SHEET NUMBER: **C-1** REVISION: **2**  
 TEP#: 50076.182952

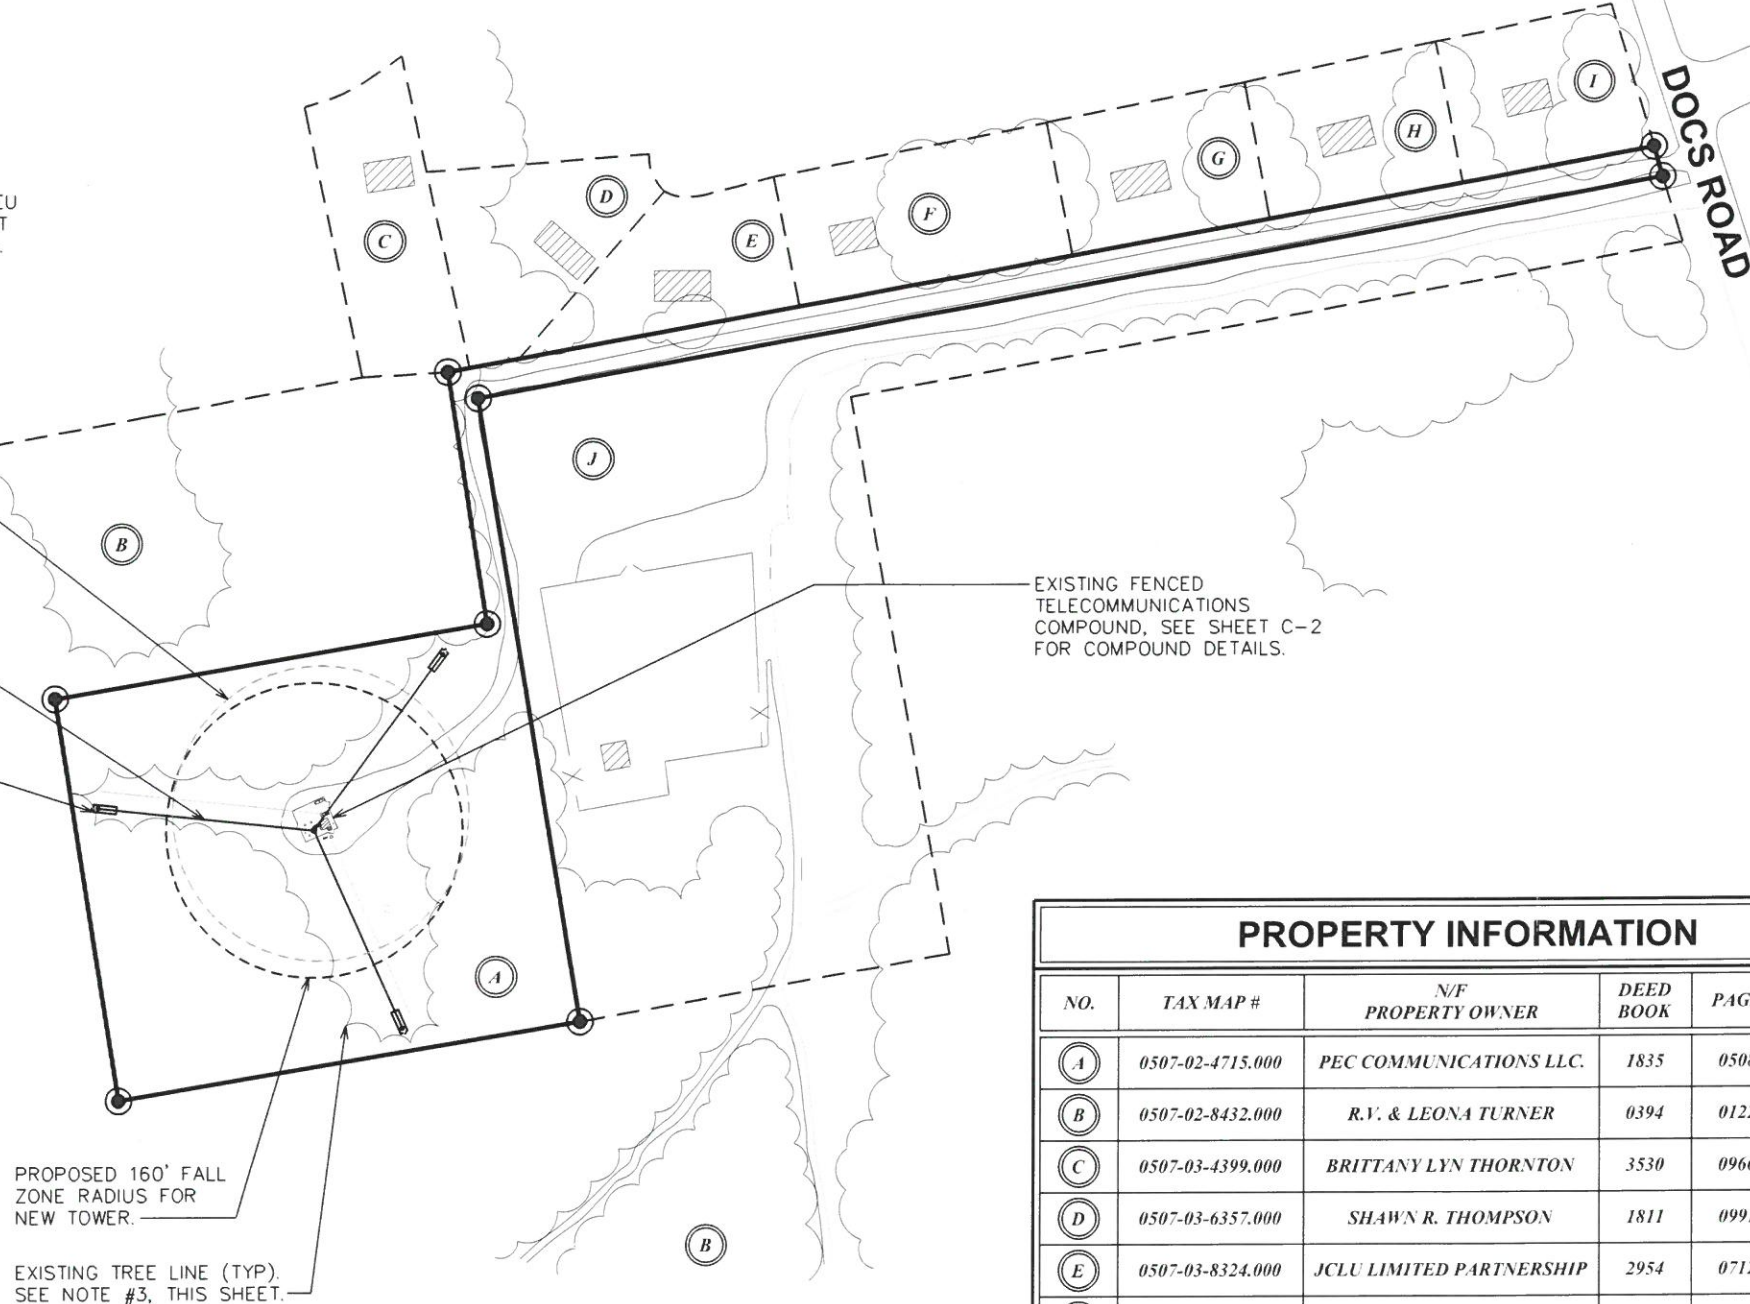
A new tower approved for mitigation of an existing tower shall not be required to meet new setback standards so long as the new tower and its equipment compound are no closer to any property lines or dwelling units as the tower and equipment compound being mitigated. The intent is to encourage the mitigation process, not penalize the tower owner for the change out of the old facility. (For example, if a new tower is replacing an old tower, the new tower is permitted to have the same setbacks as the tower being removed, even if the old tower had nonconforming setbacks.)

8. Structural fail modes – need fall zone radius
A statement that the proposed tower will have a designed fall radius that meets the existing tower setbacks is enclosed. Proposed fall zone is indicated on Site Plan.

A statement that the proposed tower will have a designed fall radius that meets the existing tower setbacks is enclosed. Proposed fall zone to be indicated on Site Plan.

14. Survey
Duke Energy to provided Survey. Survey is enclosed
 15. Signed and Sealed plans - provided
 16. Title Report
See response above in item #14
 17. List of adjacent property owners, keyed to map
Adjacent property owners are included on sheet C-1 of the Construction Documents.
Mailing labels enclosed with notarized Certification letter.

SHEET NUMBER: **C-3** REVISION: **2**

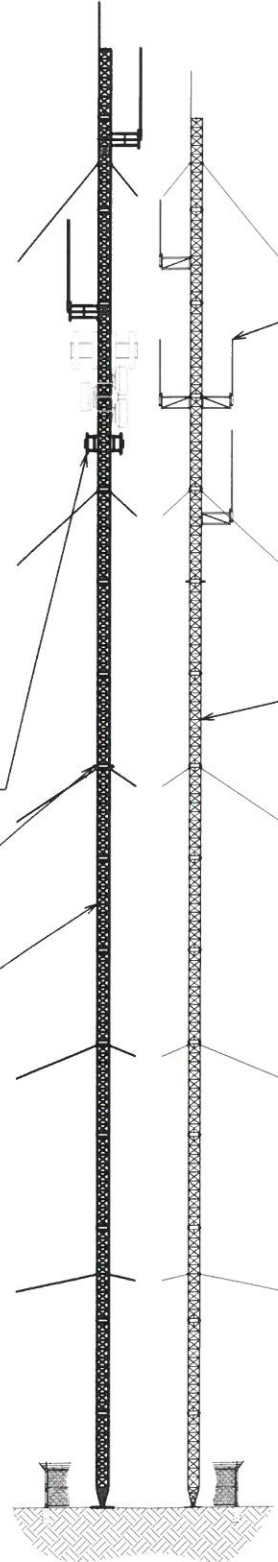
Mitigated antenna-supporting structures shall be configured and located in a manner that minimizes adverse effects on the landscape and adjacent properties, with specific design considerations as to height, scale, color, texture, and architectural design of the buildings on the same and adjacent zoned lots.

Proposed tower is a direct replacement for existing tower and will not have adverse effects on the landscape and existing properties.

5. Structural analysis - provided
 6. Locating alternatives - provided
 7. Potential visual and aesthetic impact
New tower is a direct replacement for existing tower and will not have adverse visual and aesthetic impact. Please refer to Construction Drawings, Revision 2, dated November 1st, 2018.
